**Date:** 11/01/2024

**Re:** **LVL Issue**  
Location: Lot 27 Honeycutt Hills (457 Adams Pointe Ct. (Angier, NC))  
JDS Project No.: RDU2410848  
Date of Inspection: 11/01/2024

sheet:  
**S2.0**

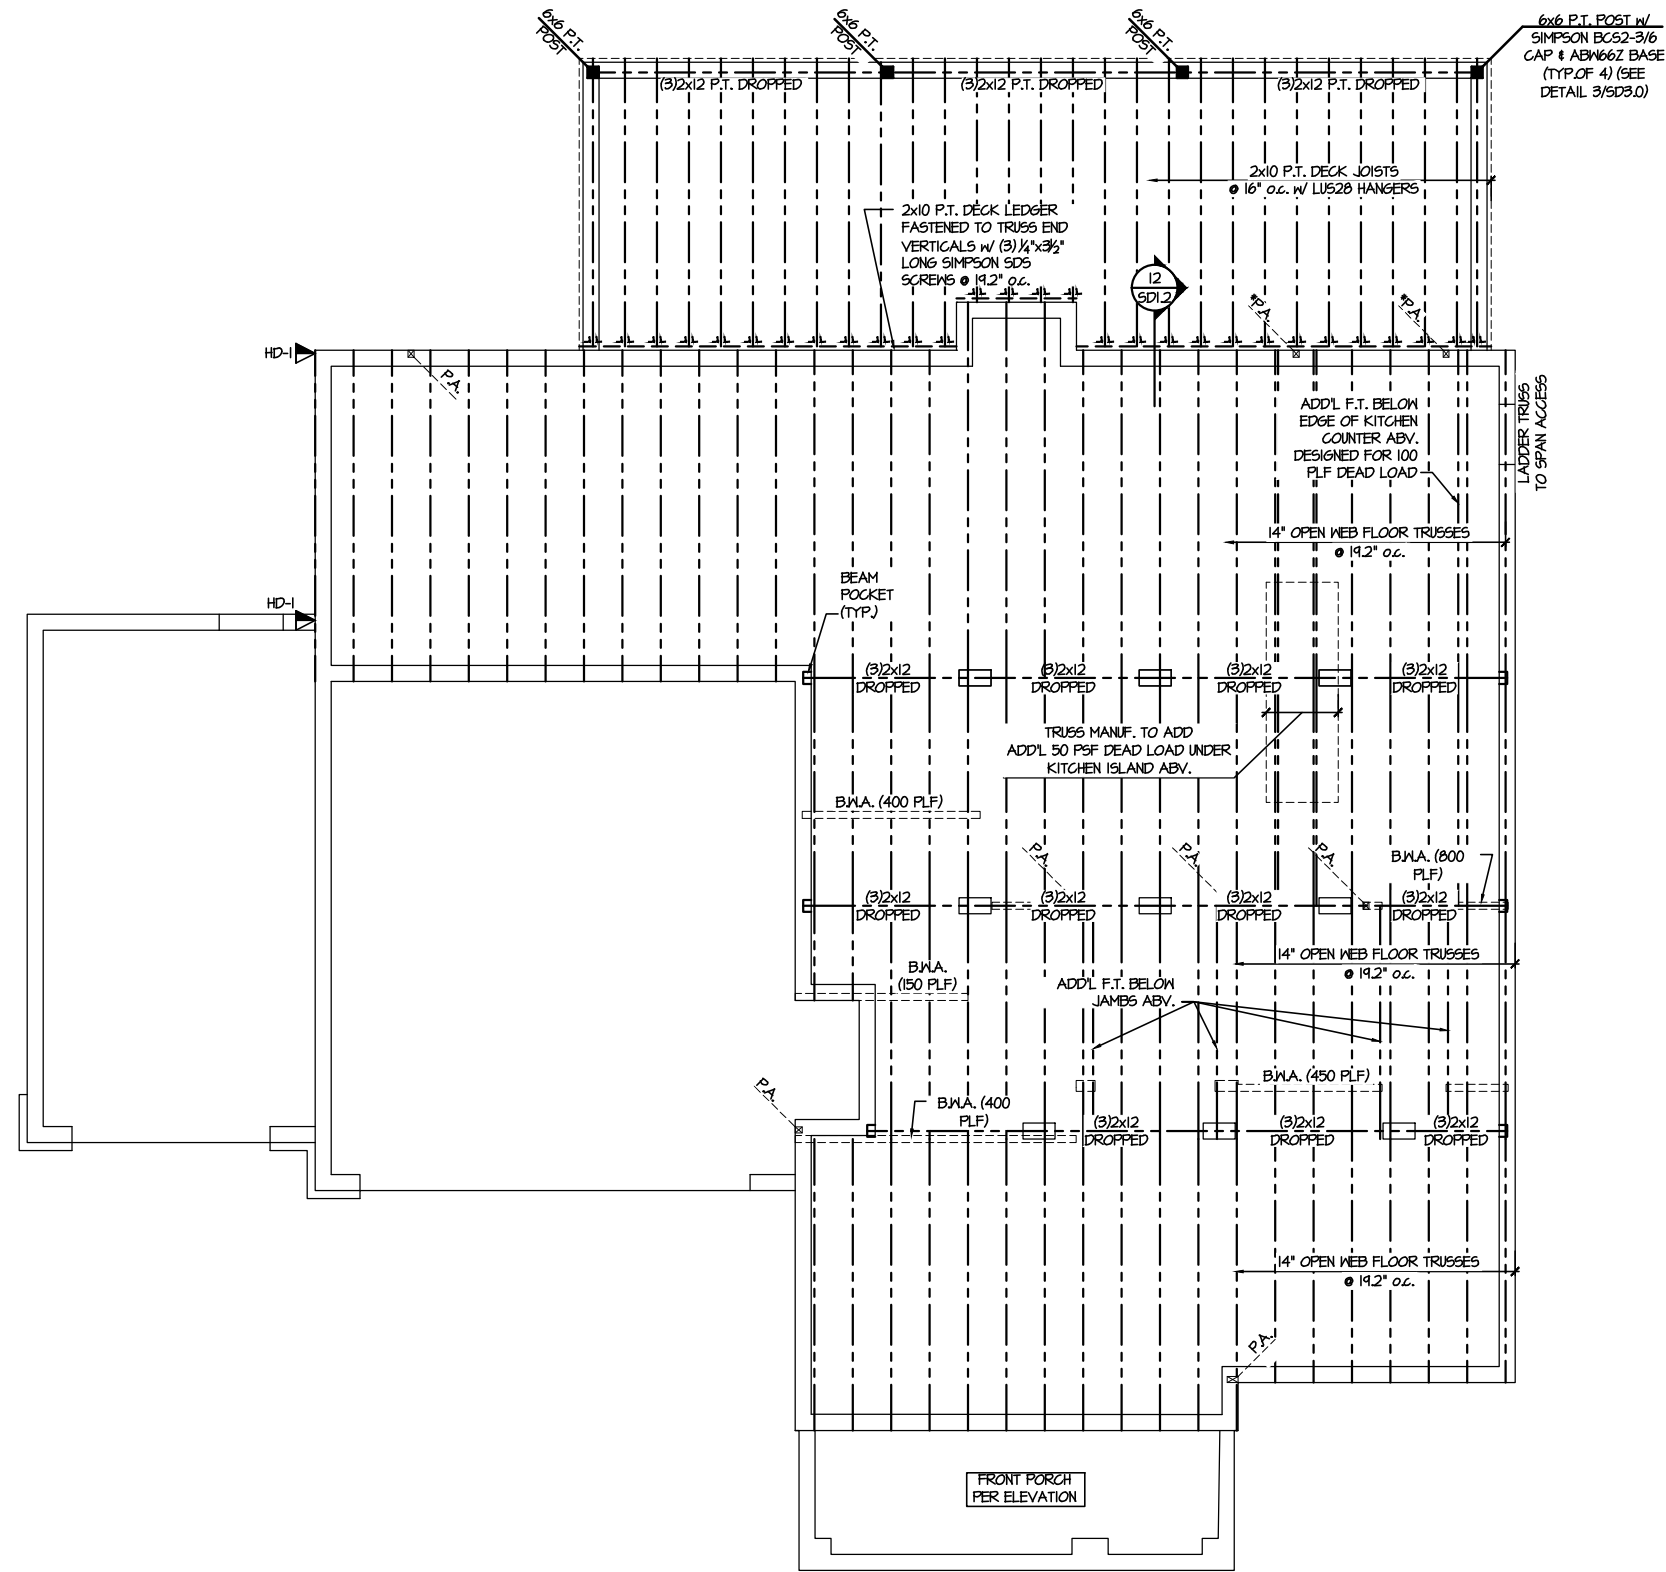
The client requested an evaluation and specifications for alternate framing at the right garage wall. The plans call for the (3) ply 1-3/4" x 18" LVL girder beam directly to the rear of the garage front door to bear on (6) ply 2x4 column. There is not sufficient clearance for stud column installation at the location.

1. Install a minimum 6'-5" long (2) ply 1-3/4" x 18" LVL over the right side inset at the main house entrance from the garage at the right of the beam. Ensure that the (3) ply girder beam is flush to the face of the newly installed (2) LVL.
2. Support the beam at both ends with a minimum (3) ply 2x4 stud column. Ensure that squash blocks are installed between the top and bottom chord of the floor trusses below directly beneath the stud column plys (1) block for every ply. Attach the squash blocks with (2) 10d toenails into the top and bottom chord. Attach the plys of the stud column with (2) rows of 10d nails spaced at 12" o.c. as well as (2) 10d nails into the top and bottom plates. Install a CS16 strap across the stud column and squash block plys.
3. Attach the existing LVL to the newly installed LVL with a Simpson HGUS5.50/14 hanger with (2) additional Simpson GA1 angles on each side.
